Our Ref: BR/62/18/HH

**Town & Country Planning Act 1990 (as amended)
Town & country Planning (Development Management Procedure) (England) Order 2015
Application for Planning Permission for Works or Extension to a Dwelling**

Development Demolition of existing rear extension & construction of single storey rear extension
Location 58 Hillsboro Road Bognor Regis

9 Site Plan
1 : 200

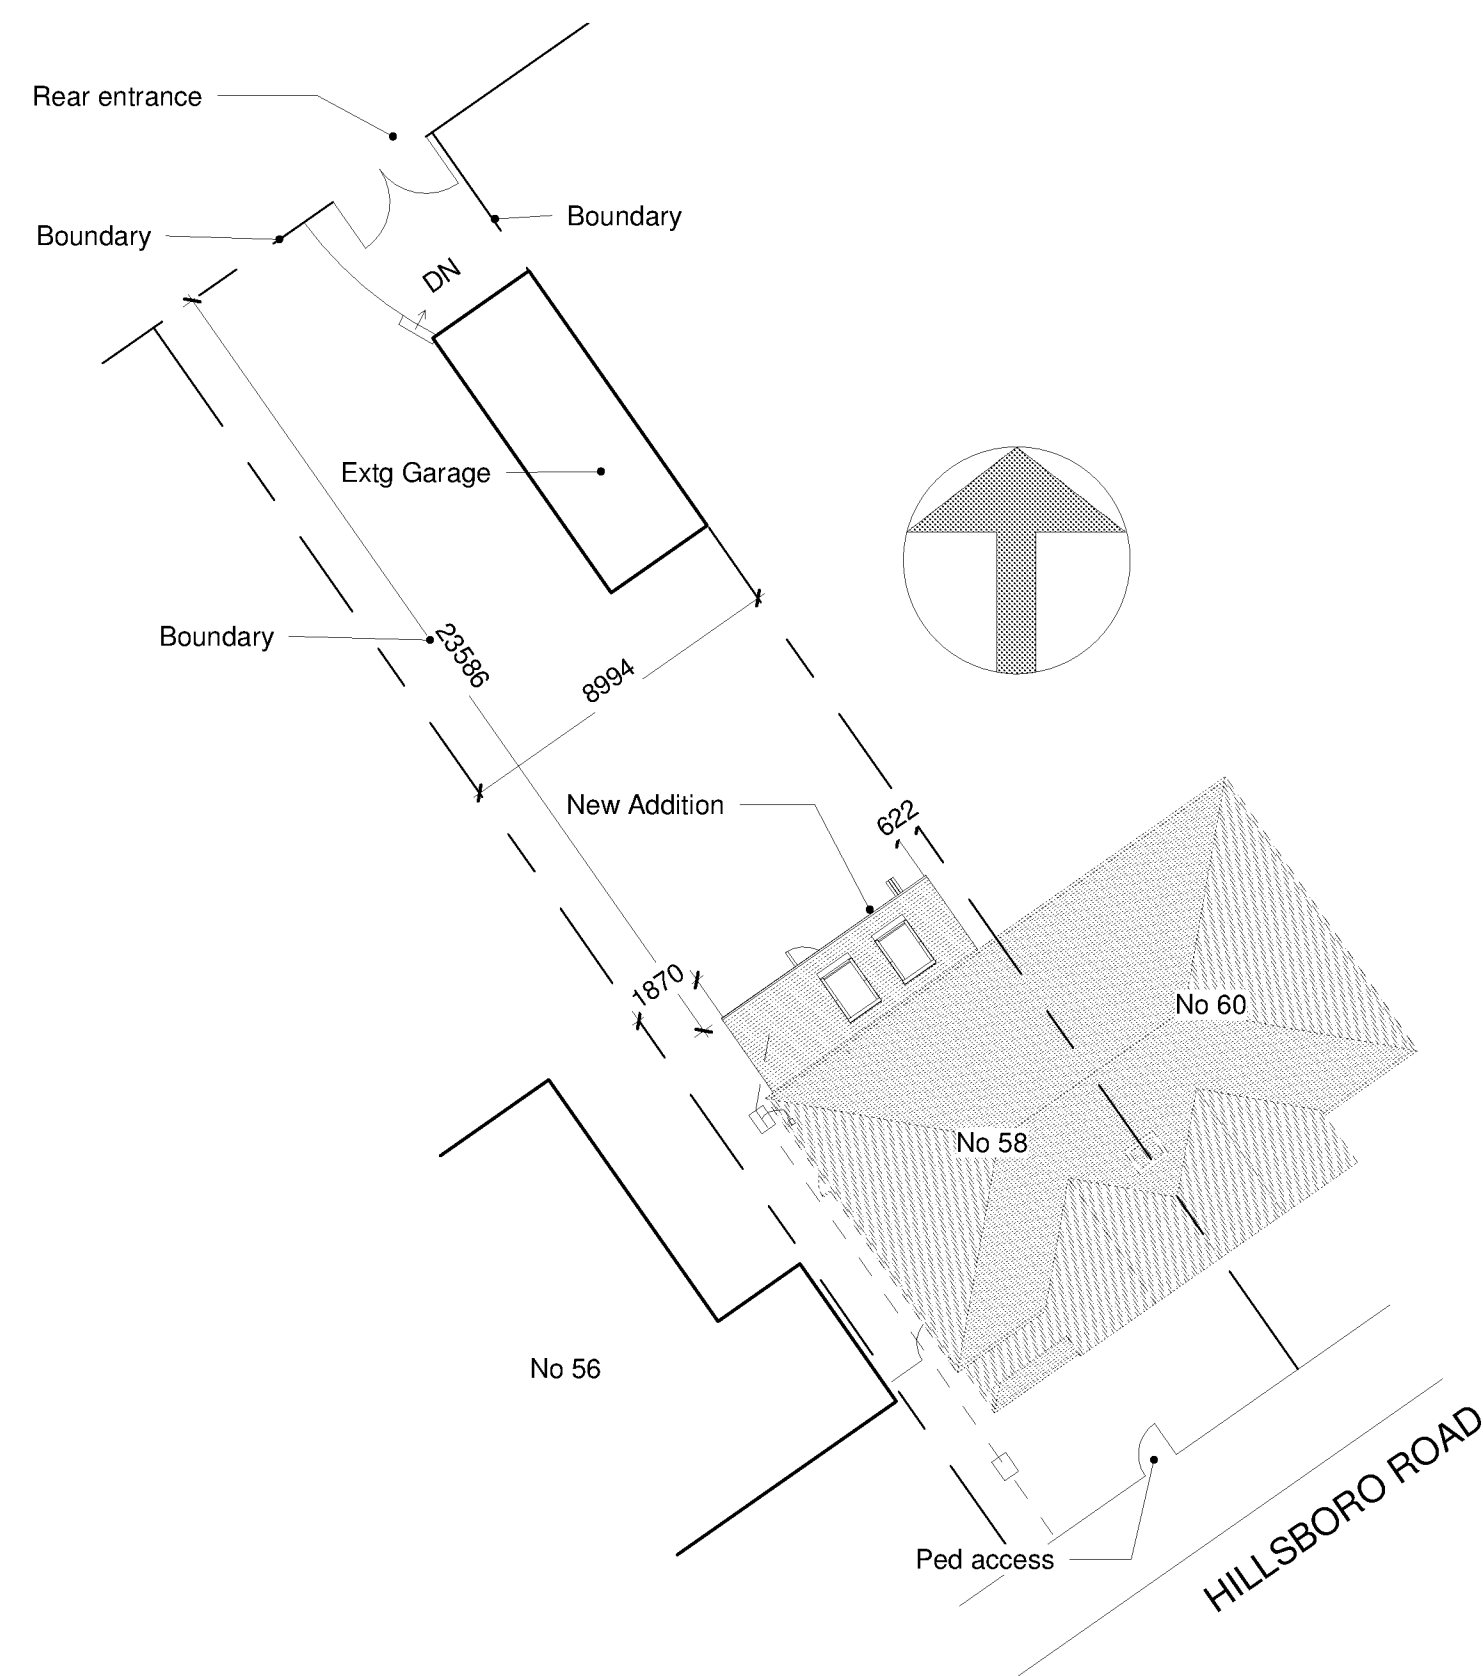
Block Plan - revised

Please submit 1 electronic or 3 paper copies of a revised block/site plan at a scale of 1:500 or 1:200 with the site dimensions from the proposals to the site boundaries clearly indicated. Further details of what must be included on the plan can be found in the National Validation Requirements.
